## Appeal Decision

### Appeal Ref: 6002647

### Land Adjacent 38 Upper Road, Batley Carr, WF17 7LT

- The appeal is made under section 78 of the Town and Country Planning Act 1990 (as amended) against a refusal to grant planning permission.
  - The appeal is made by Mr Nazir Rajah against the decision of Kirklees Council.
  - The application Ref is 2025/62/92758/E.
  - The development proposed is described as “proposed dwelling”.
-

PROPOSED HOUSE
ADJACENT
38 UPPER ROAD
BATLEY CARR

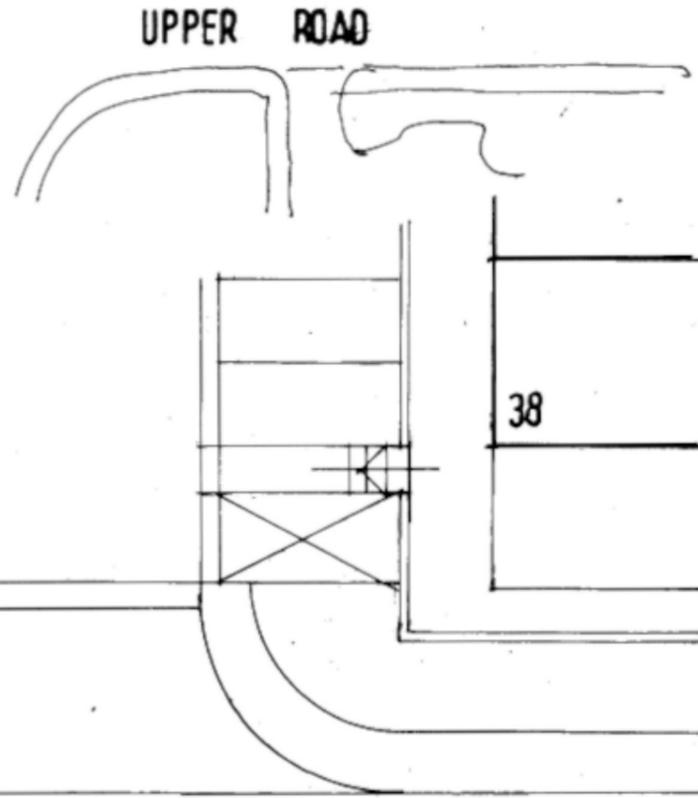
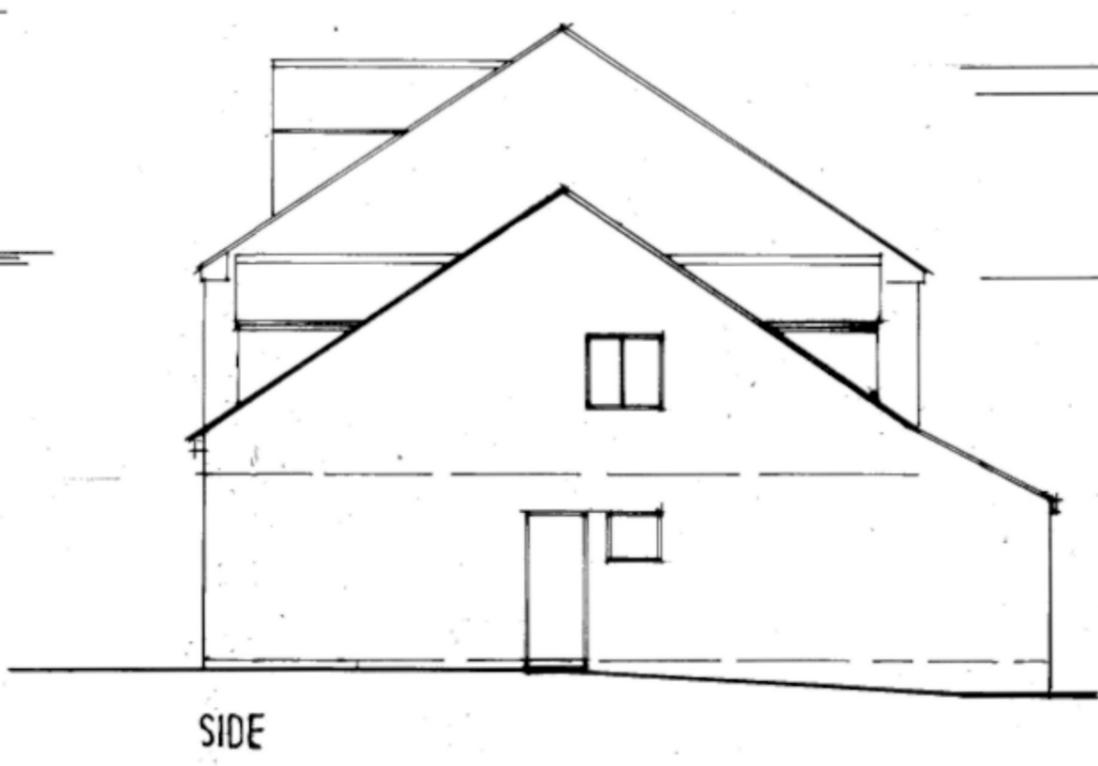
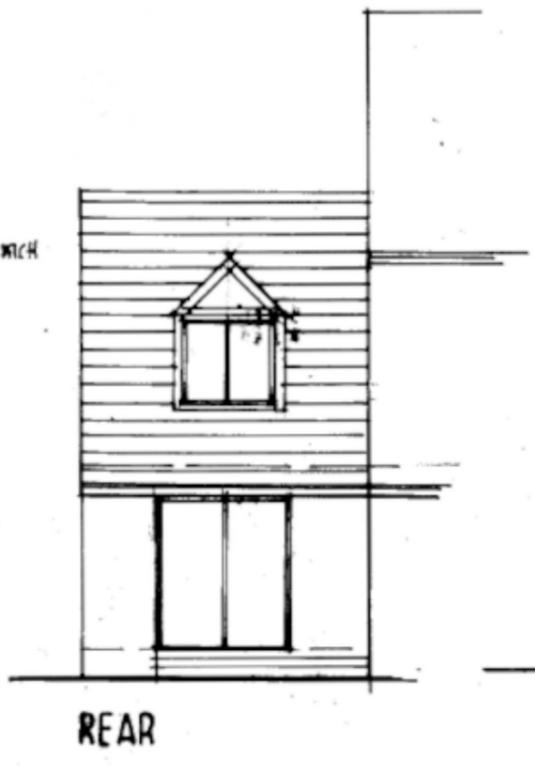
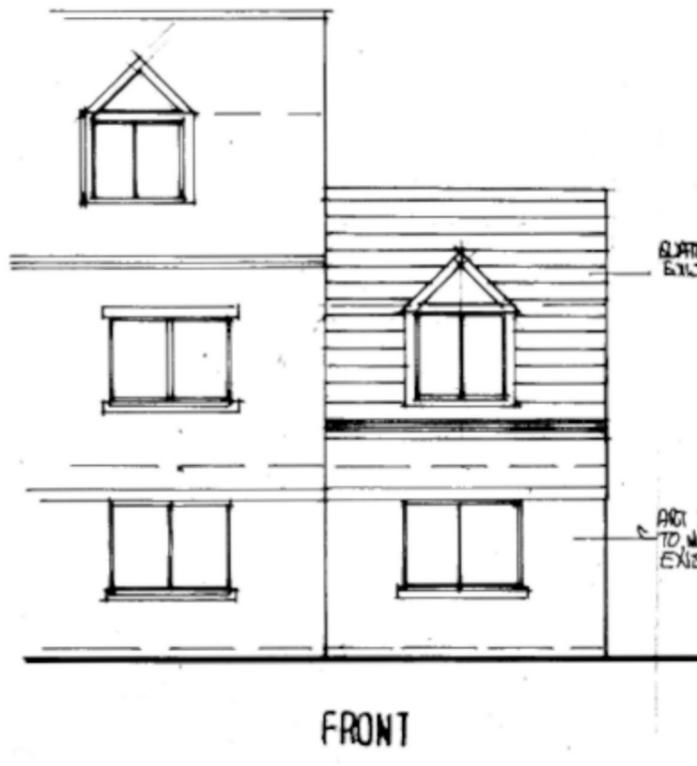
4. The proposed dwelling would adjoin the modern two-storey terrace block. Each dwelling within this terrace features small dormer windows within the front roof slope and rooflights to the rear roof slope. The proposed dwelling would appear as a single storey extension to the terrace row, albeit with a discordant eaves level, with similar front dormer window, noticeably narrower footprint, side entrance door and an additional rear dormer window. These elements combined would result in a contrived and cramped appearance that sits uncomfortably with the established terrace form and wider area. Furthermore, its height and bulk would erode the established open character.

6. The adjacent modern terraced dwellings are set back from Upper Road, with open space on the corner, allowing long views of the church from the west. Owing to the height and position of the proposed dwelling, it would obscure views of the church from the western approach, including its key architectural features, such as its buttresses and a substantial part of the tower. Furthermore, the incongruous design of the proposed dwelling would detract from the prominence of the church within its setting. I therefore find that the proposal would adversely affect the setting of the Holy Trinity Church such that it would not preserve its special interest, contrary to the statutory duty.

8. My attention has been drawn to an extant permission for a new dwelling in the same position and with the same footprint as the current proposal. However, the approved scheme is for a single storey building with a lower eaves and ridge height and simpler roof design. The proposal before me has a considerably larger built form, given the increased eaves and ridge heights and the introduction of dormer windows to the front and rear roof slopes. The impact of the appeal scheme on the character and appearance of the area, including the setting of the listed building, is therefore more harmful and as such I afford limited weight to this fallback position.
